MECKLENBURG COUNTY
Park and Recreation Department

MEMORANDUM

DATE: August 23, 2023

RE: Rezoning Petition #2023-046
PID# 22916101, 05, 03, 84

SCHEMATIC SITE PLAN

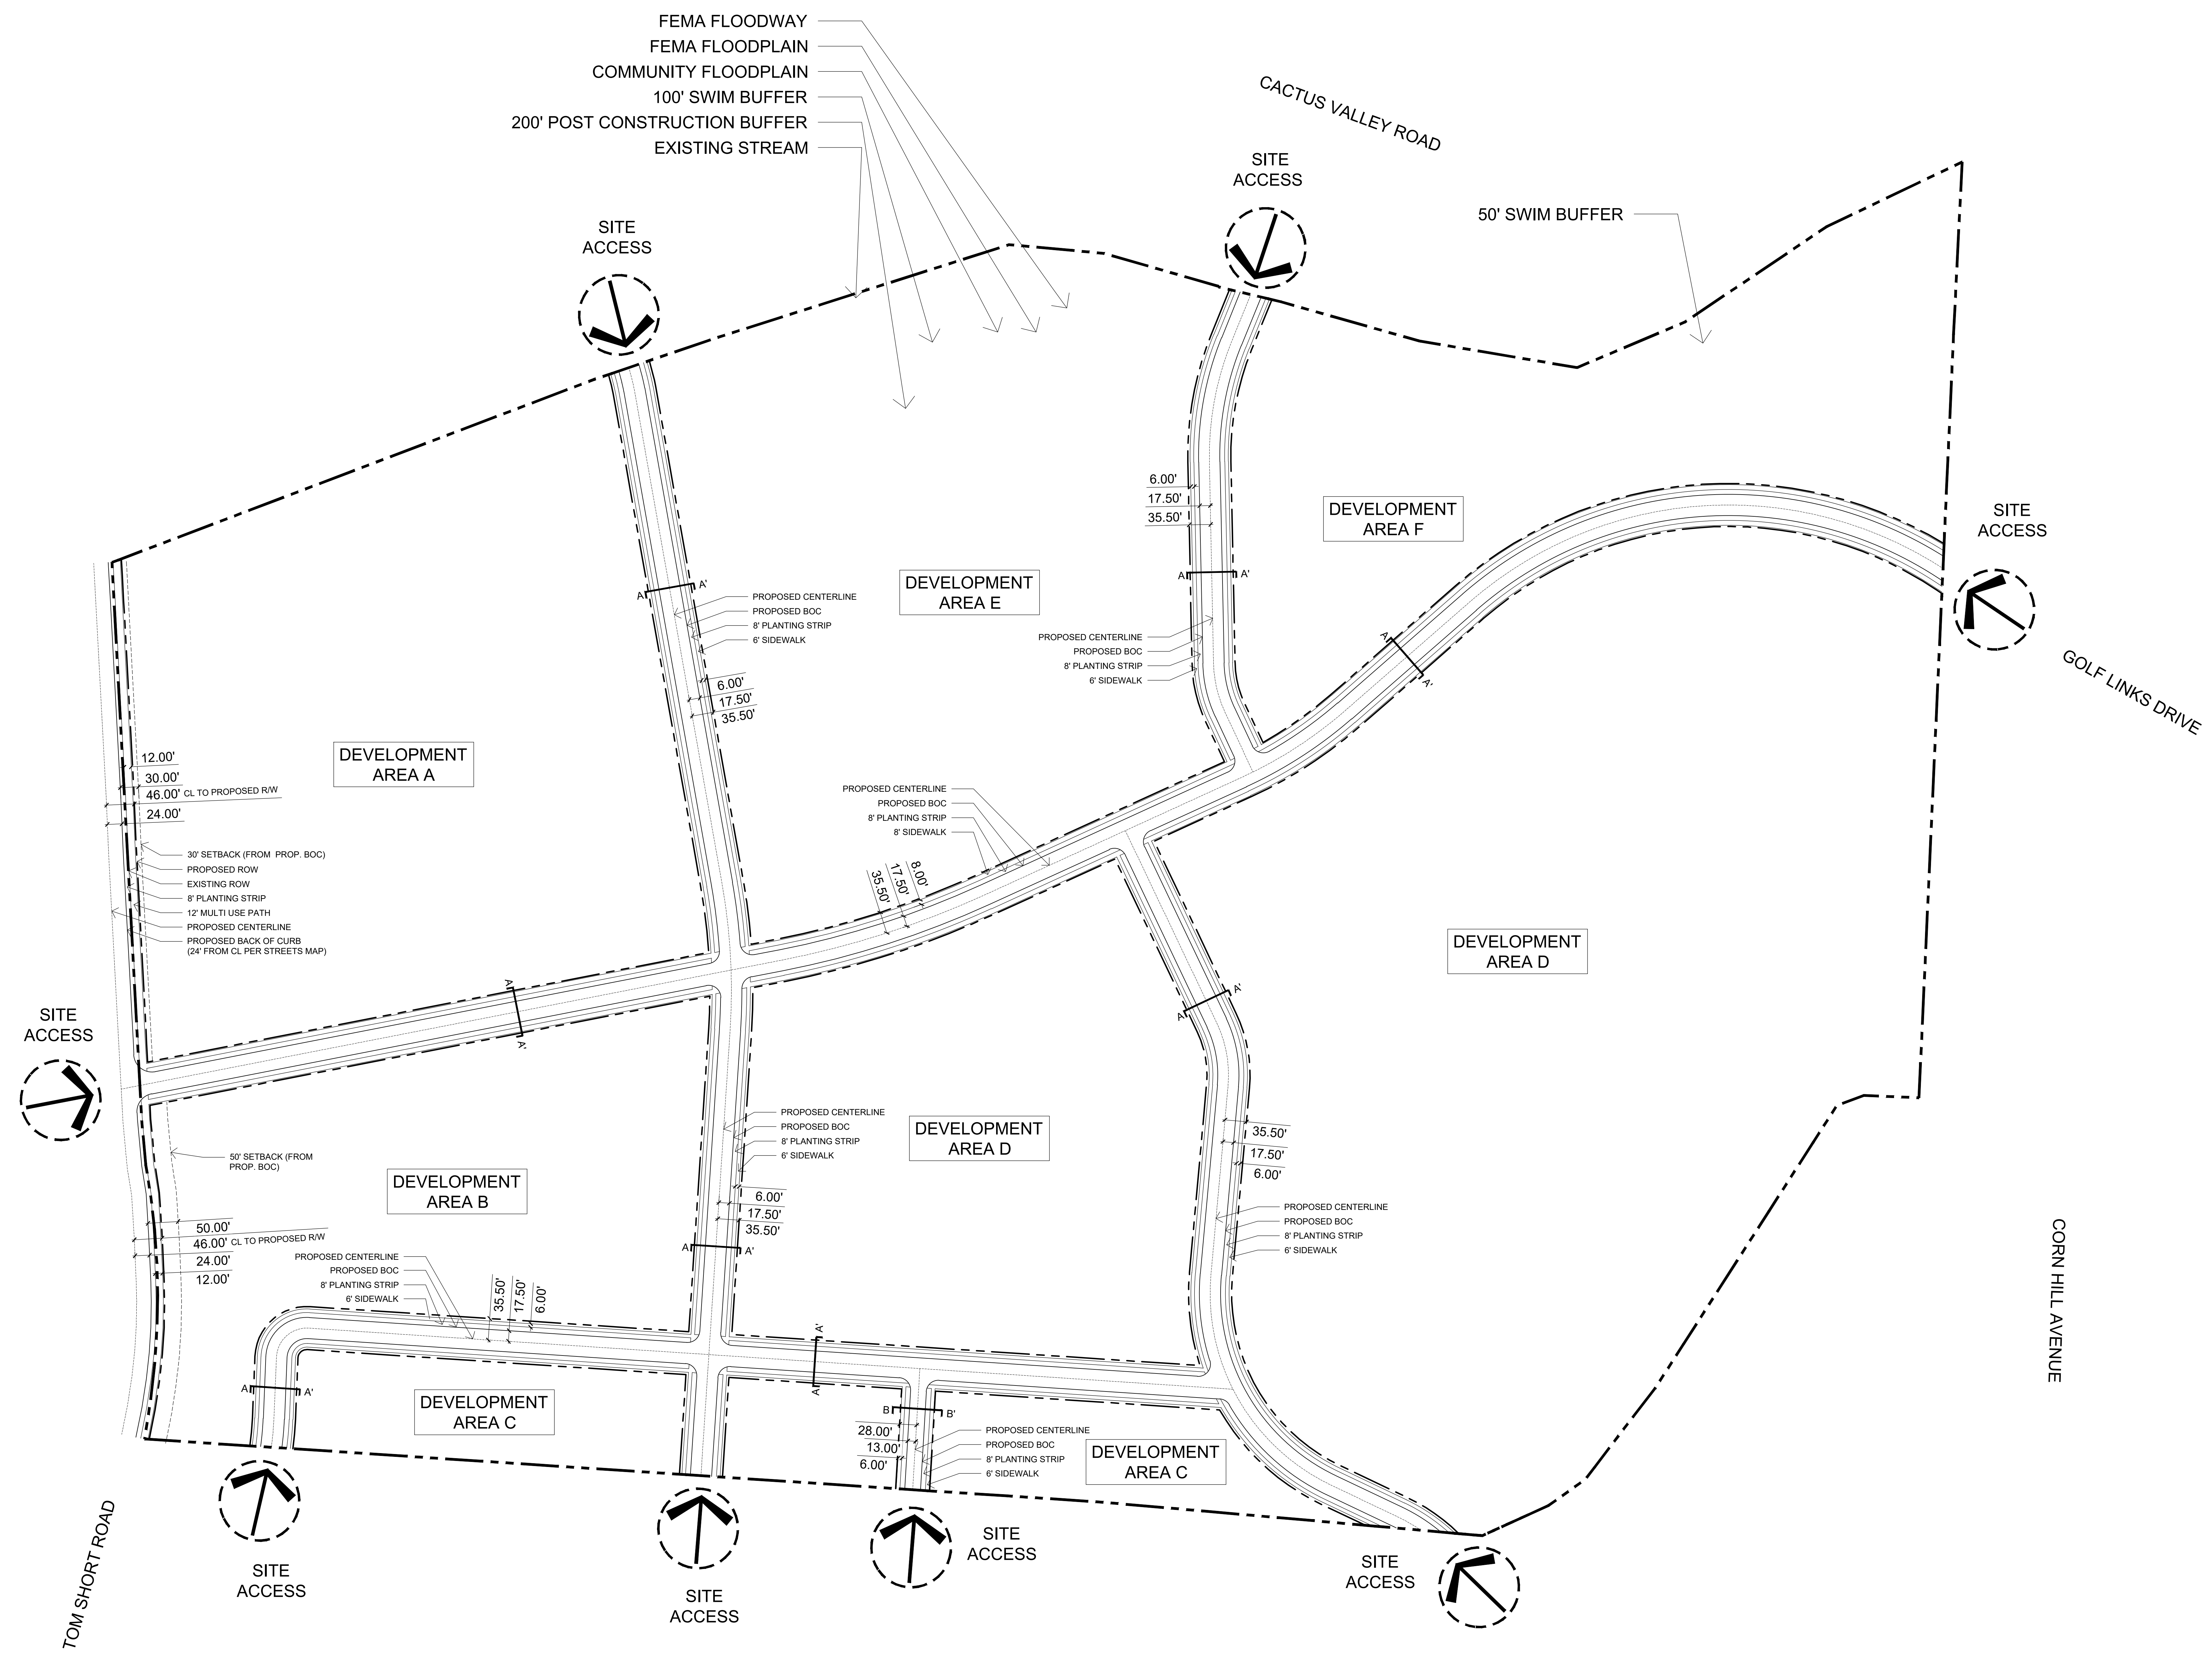
MCPR requests minimum of **2.0** acres to be dedicated and conveyed to Mecklenburg County for a future local park on the East side of the development. This requested park land shall be adjacent to a public right-of-way for access and is conducive for the development of the typical amenities found in a local park and cannot include tree save parcels or stormwater BMP's.

Additionally, MCPR requests the dedication and conveyance of the 100' SWIM or a minimum of a 100' width easement along Flat Branch to Mecklenburg County as permanent greenway easement. Greenway easements may overlap tree-save. Greenway easements and parkland dedication shall be conveyed by the first CO.
